GATWICK AIRPORT NORTHERN RUNWAY PROJECT

Planning Inspectorate's Reference: TR020005

CONSOLIDATED SUBMISSIONS ON THE DRAFT DEVELOPMENT CONSENT ORDER

Deadline 7: Monday 15 July 2024

Title
Gatwick Business as Usual (BaU) Signalisation Scheme Concept Design APFP Regulations 5(2)(q) - Sheet 1 Highway Layout Plans - North Terminal

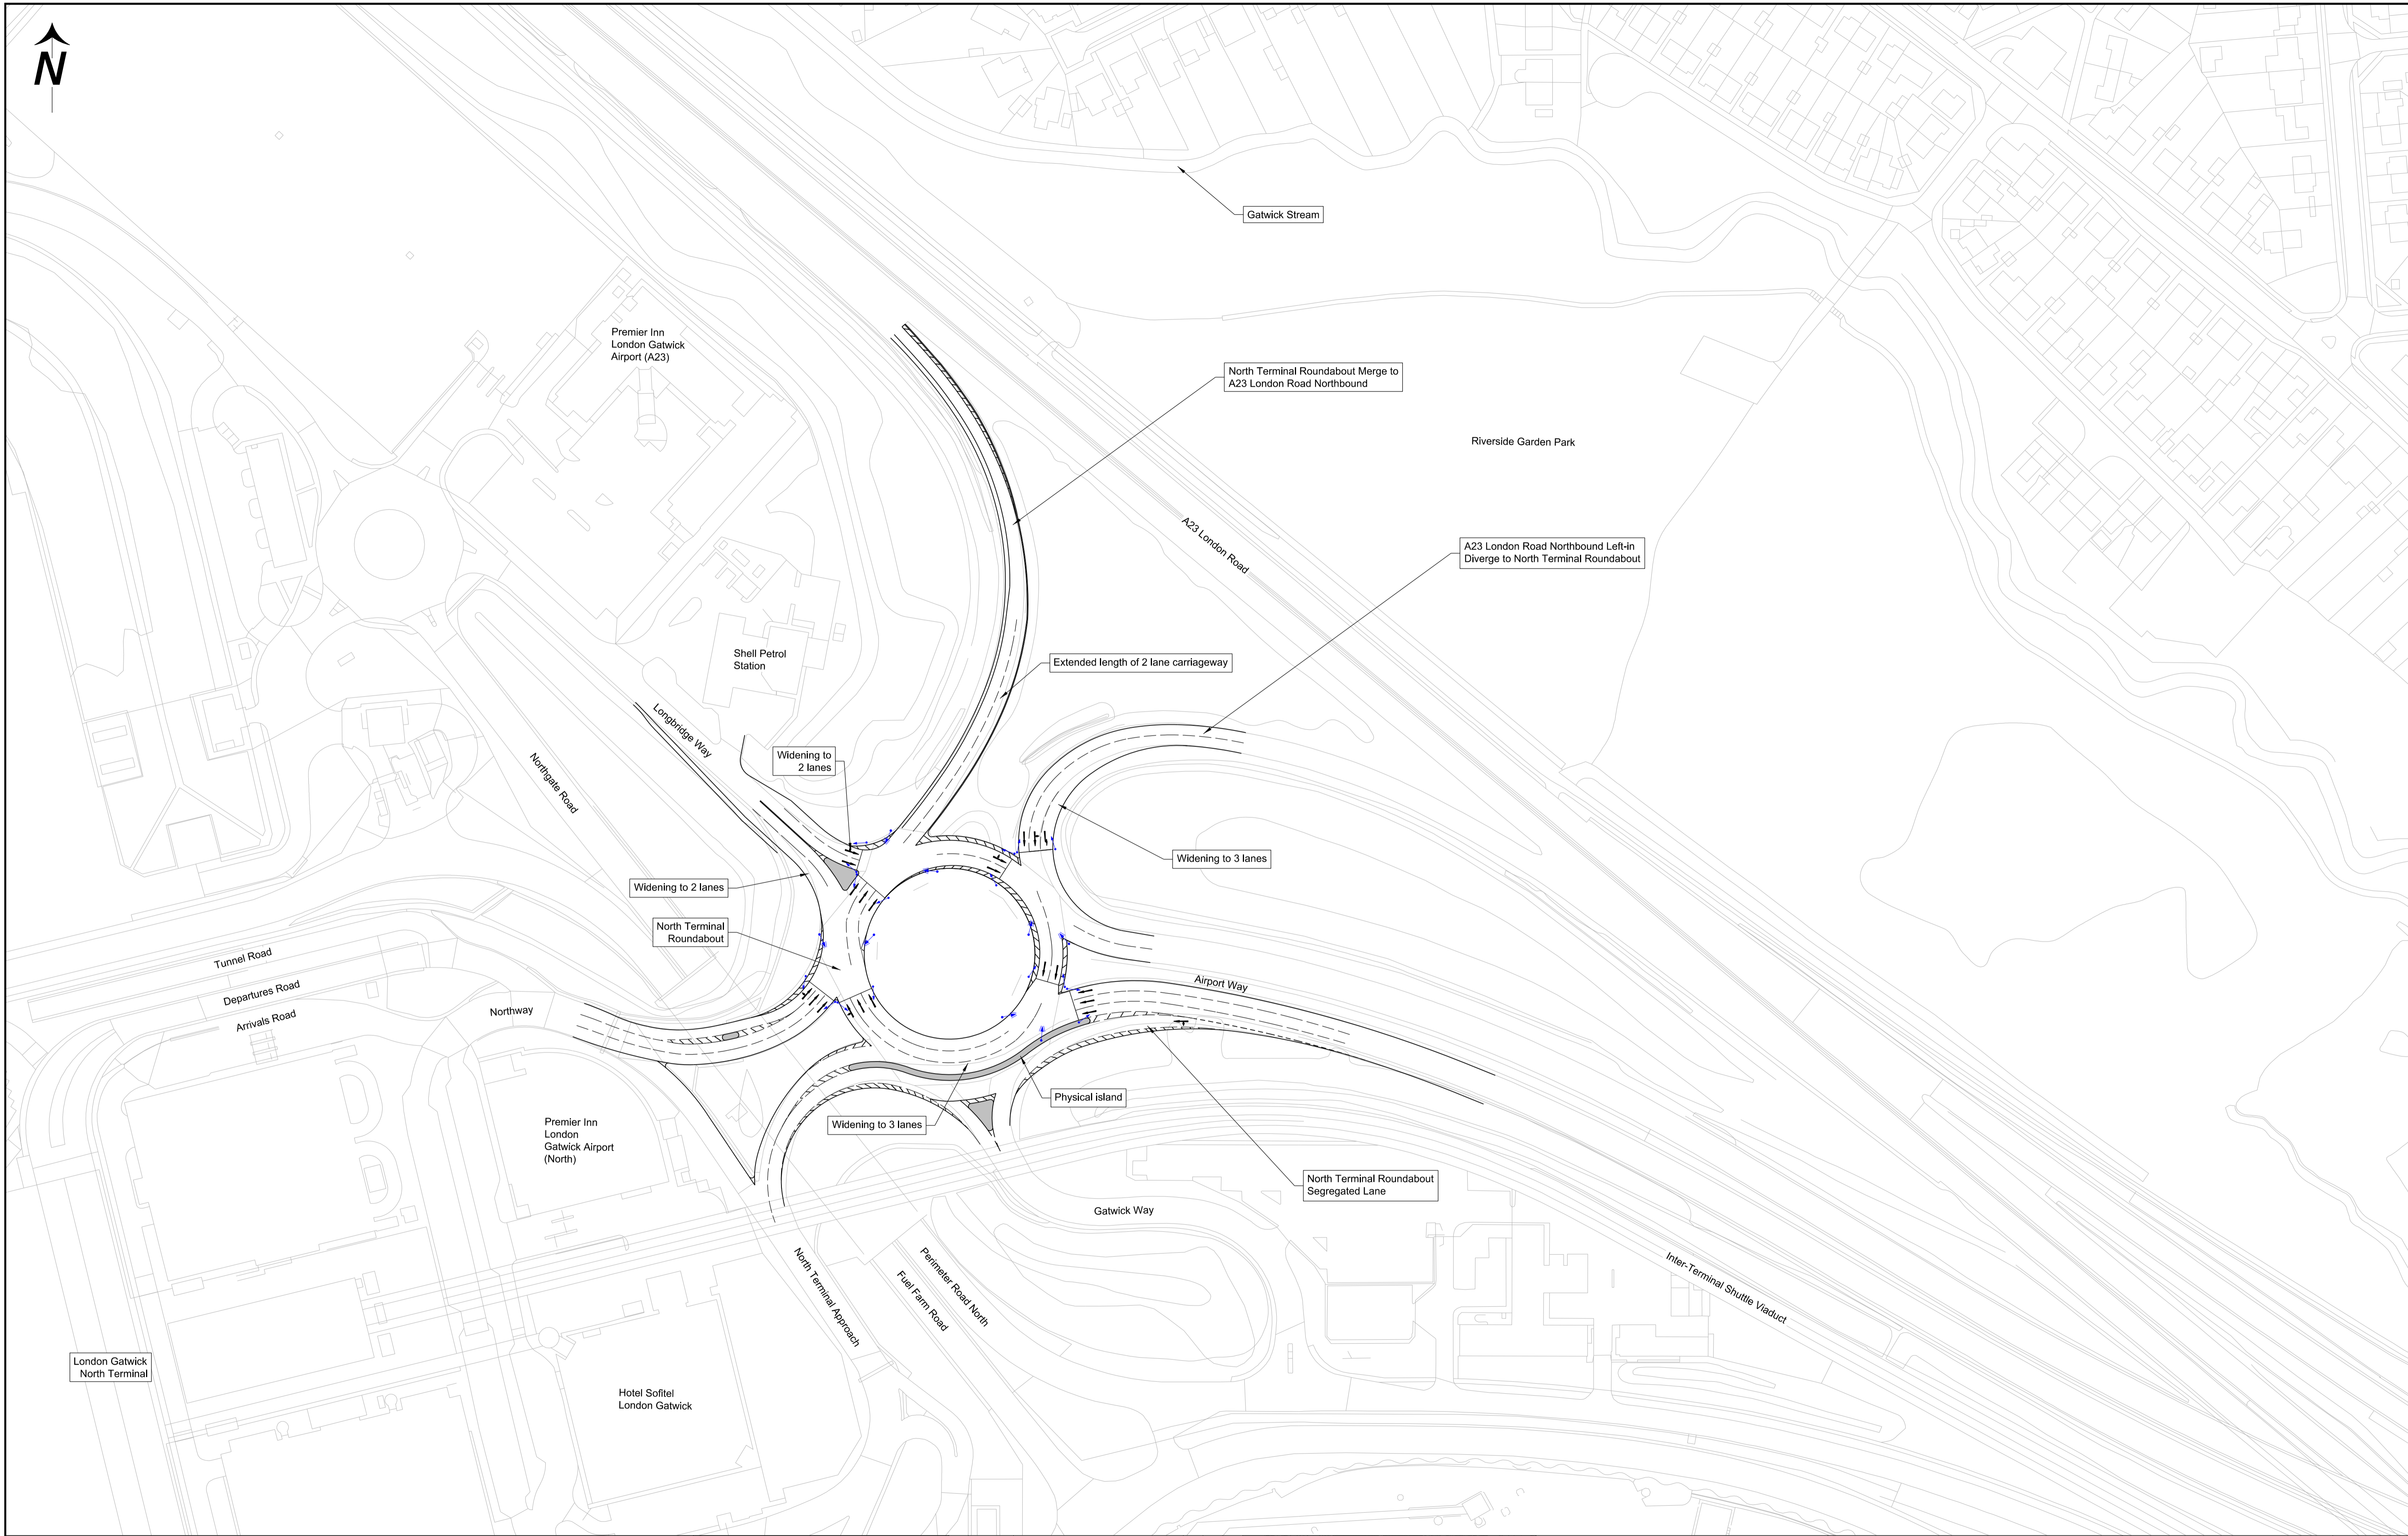
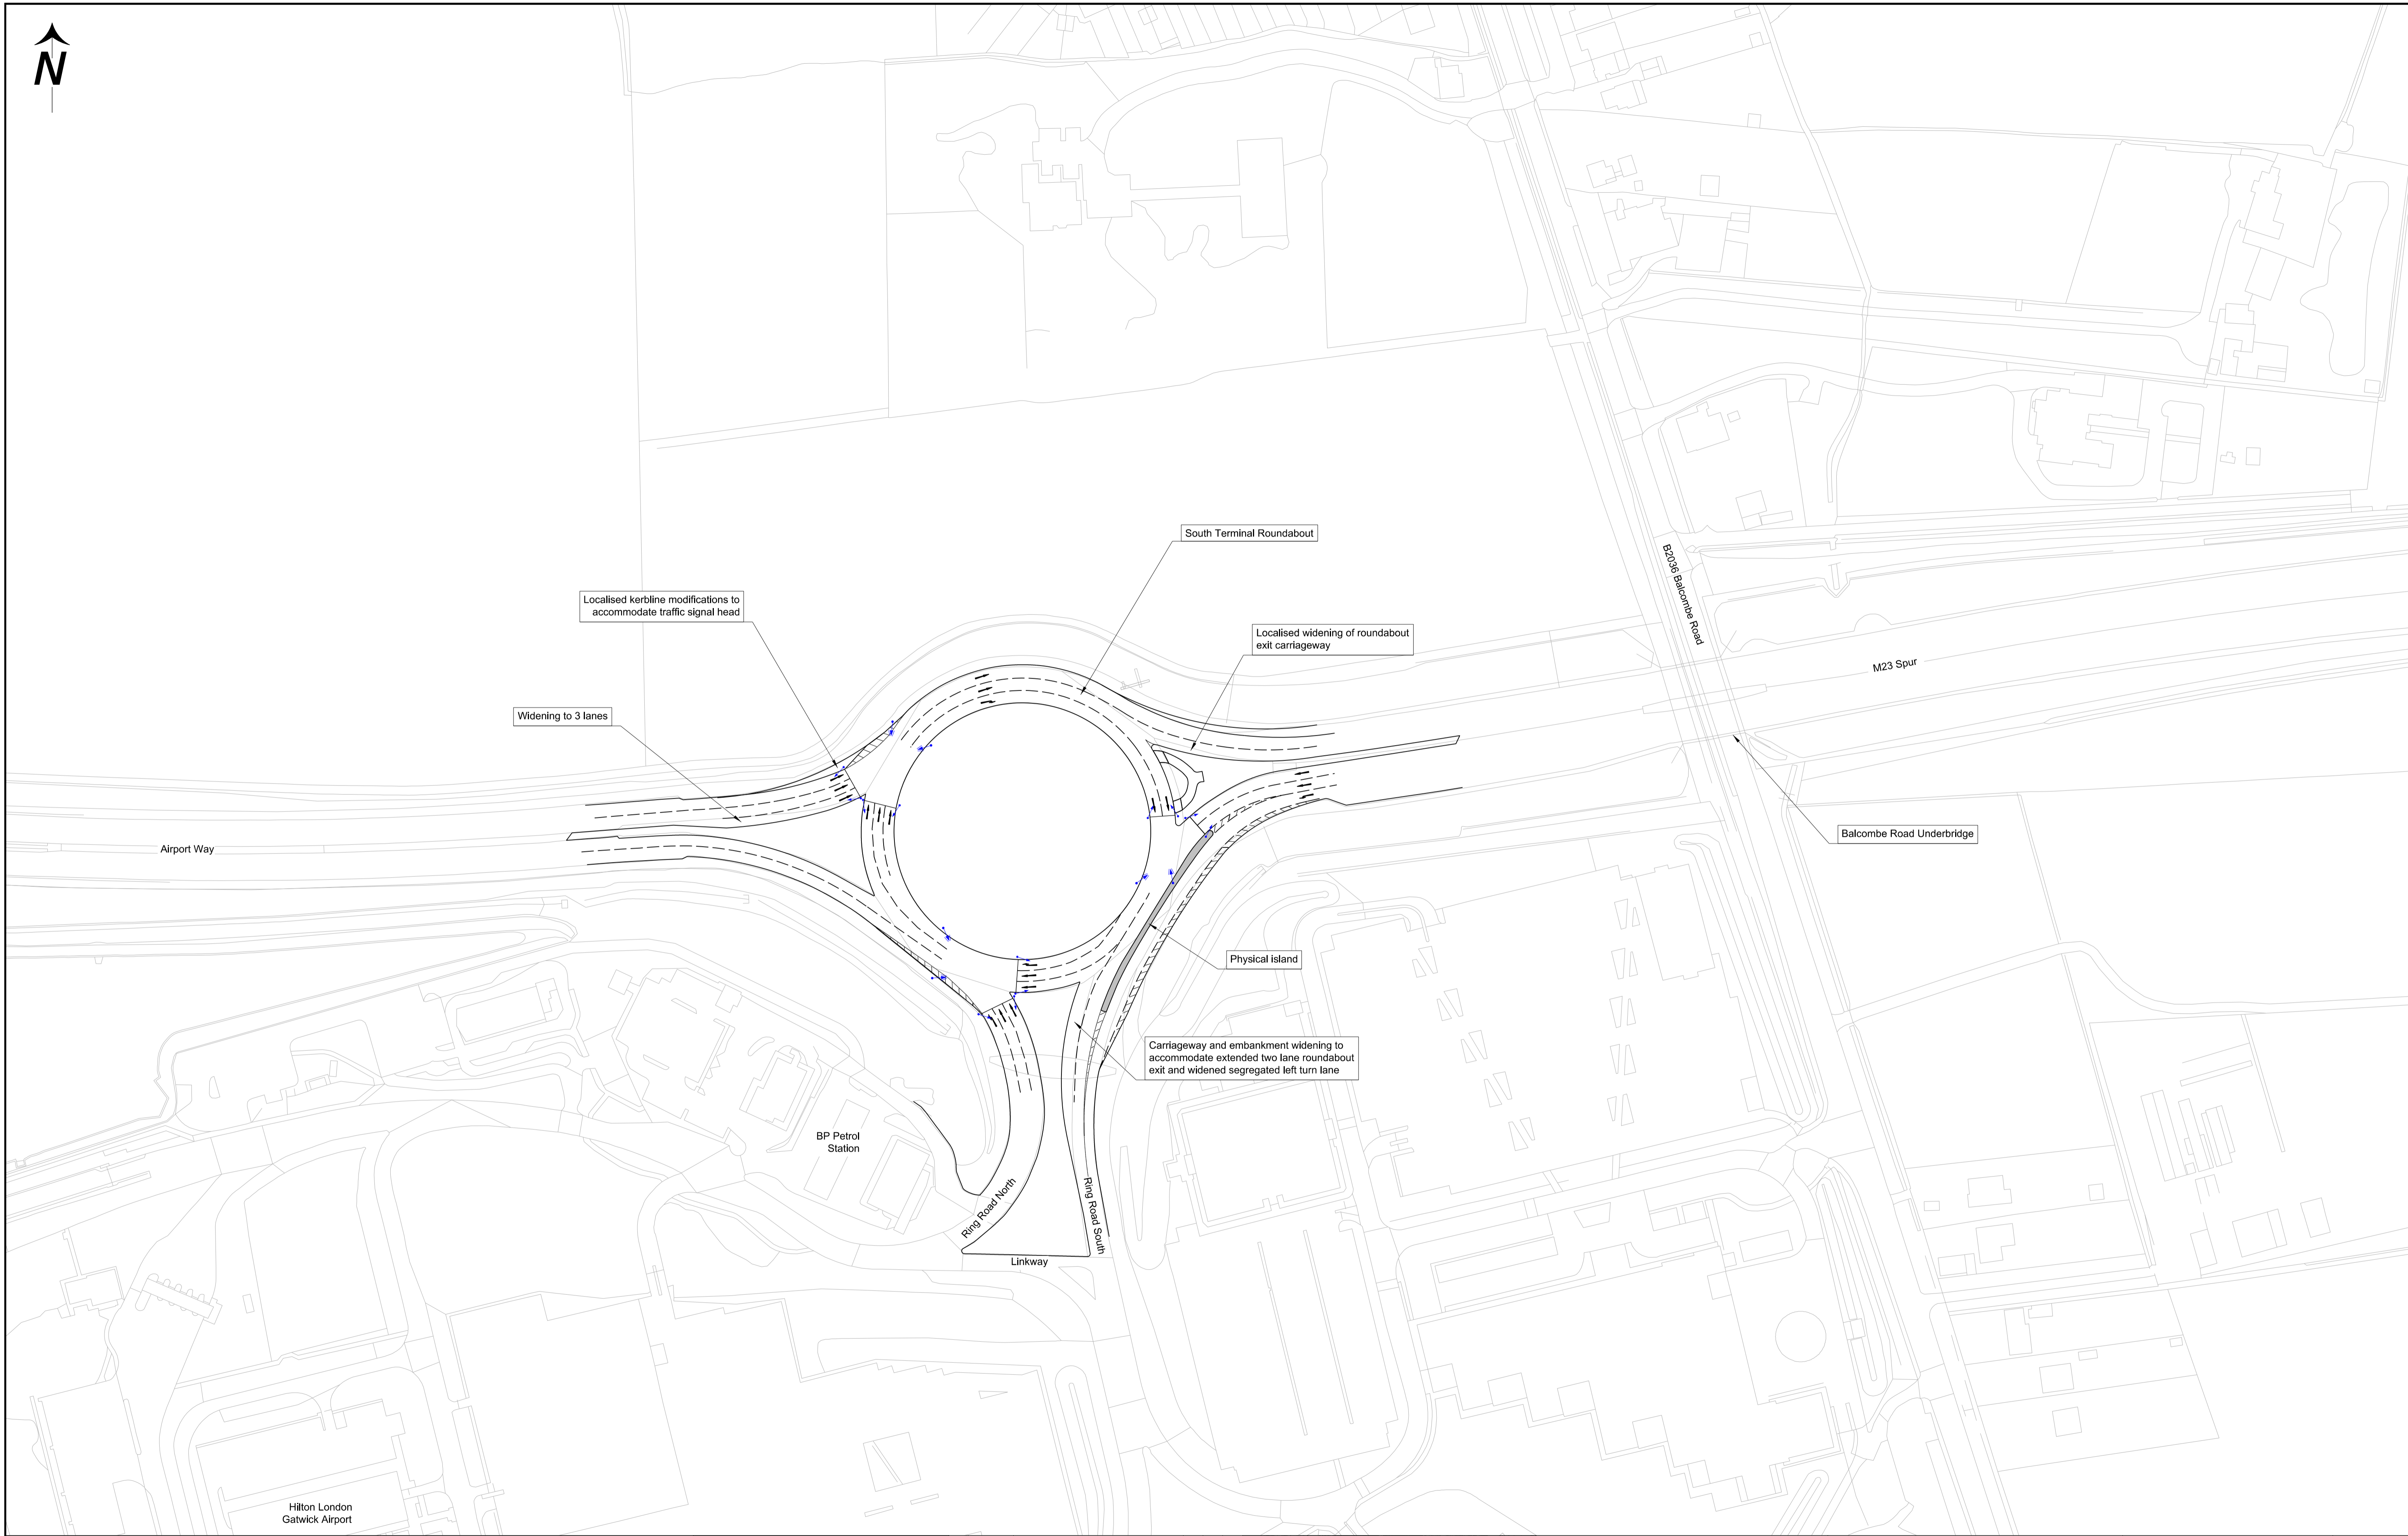
<p>157.</p>	<p>Requirement 33 (North and South Terminal roundabouts BAU improvement scheme)</p>	<p>New requirement 33: North and South Terminal roundabouts BAU improvement scheme 33.—(1) Prior to the first of— (a) the commencement of dual runway operations; (b) the commencement of the first of Work Nos. 35 (South Terminal Junction improvements) and Work No. 36 (North Terminal Junction improvements); or (c) the third anniversary of the commencement of the authorised development, the North and South Terminal roundabouts BAU improvement scheme must be completed, unless otherwise agreed with National Highways. (2) In this requirement— (a) "North and South Terminal roundabouts BAU improvement scheme" means a scheme of construction, not forming part of the authorised development, to implement traffic signal control and add further entry and exit lane and roundabout circulatory capacity at the North and South Terminal roundabouts, to be agreed with National Highways and to be in general accordance with the</p>	<p>Added at the request of, and following agreement of the wording with, National Highways. This requirement secures the delivery of the 'North and South Terminal roundabouts BAU improvement scheme', a scheme of works not comprised in the authorised development but which forms part of the Applicant's transport modeling.</p>	<p>The Authorities do not have specific comments on this amendment at this time but refer the ExA to their response to ExQ2 question TT 2.12 – in the <u>Legal Partnership Authorities' Response to ExQ2</u>, for further information on their concerns regarding pedestrian and cycle crossings to enable safe active travel.</p>
